**CITY OF PORTLAND, MAINE
DEVELOPMENT REVIEW APPLICATION
PLANNING DEPARTMENT PROCESSING FORM
Planning Copy**

RE: Pennell Ave- Street Extension
CBL: 347 A008001
Application ID: 2007-0193

On January 29, 2008, the Portland Planning Authority approved a minor site plan for the roadway extension of 25.5 feet on Pennell Avenue as shown on the approved plan dated 12.18.2007. The Planning Authority approved the application with conditions as presented below.

From: William Clark
To: Philip DiPierro
Date: 1/29/2008 2:06:56 PM
Subject: Pennell Avenue - Proposed Extension.

DETAIL OF STREET ACCEPTANCE AREA

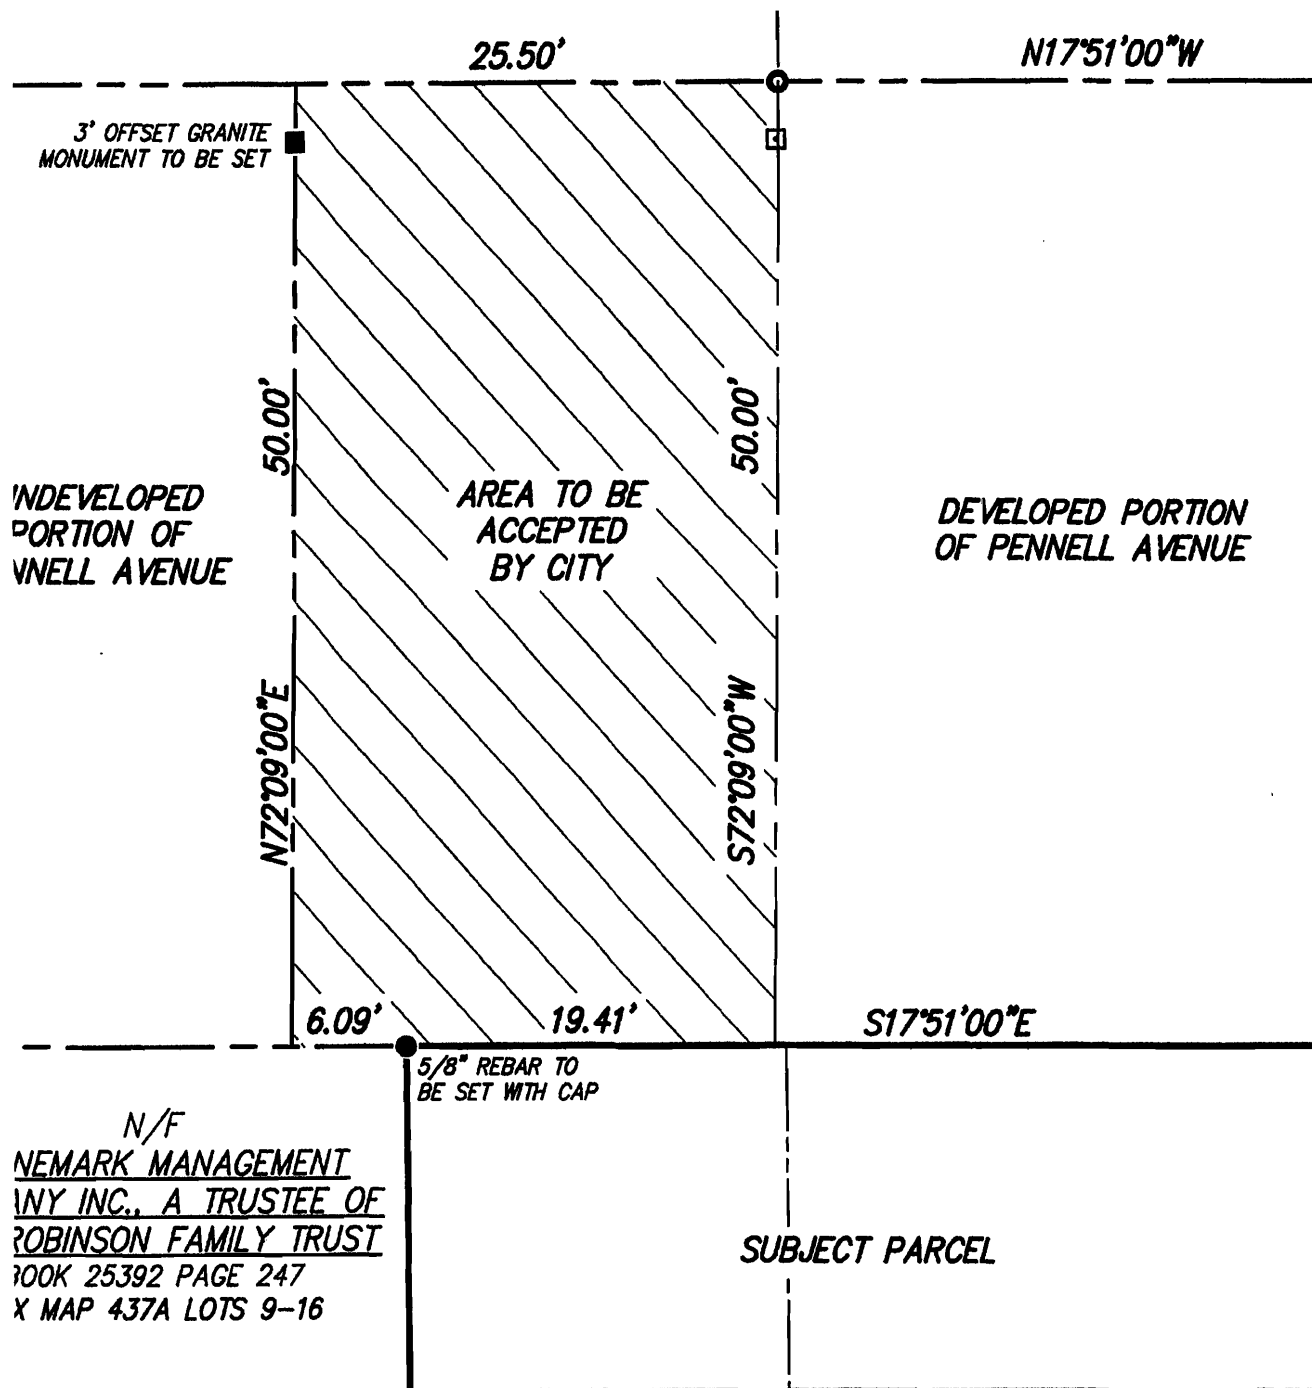
- 1/30/08 done
1. Final Plan will need to show the area to be accepted for the City Council action. They do not show the end of the proposed acceptance; just the end of pavement, gravel apron, guard rail, and silt fence.
 - 1/30/08 done
 2. Bearings and distances for the area to be accepted need to be added to the Final Plan.
 - 1/30/08 done
 3. The proposed monument needs to be shown correctly on the Final Plan. It needs to be set where the 3.00' offset line intersects the end of the street to be accepted (not as shown on the 12 06 07 plan where the 3.00' offset line intersects the plane of the end of pavement).

- need to do
4. Second Paragraph. Change "Commencing at a stone monument" to "Beginning at a stone monument".
 - need to do
 5. First Course. The distance should be 47.00' (not 47.02'). The monument referred to was the end of the street acceptance at the 3.00' offset line for the street. The City of Portland accepted the previous extension of Pennell Avenue with that granite survey monument at the 3.00' offset line.
 - need to do
 6. Last Course. The distance should be 3.00' (not 2.98'). Same comment as #5.

- need to do
7. "A certain lot or parcel of land"... "located generally within the right-of way of Pennell Avenue and at the end of the developed portion of the street".

Remove "generally"; The lot or parcel lies entirely within the right-of-way of Pennell Avenue.

Change "developed" to "accepted".
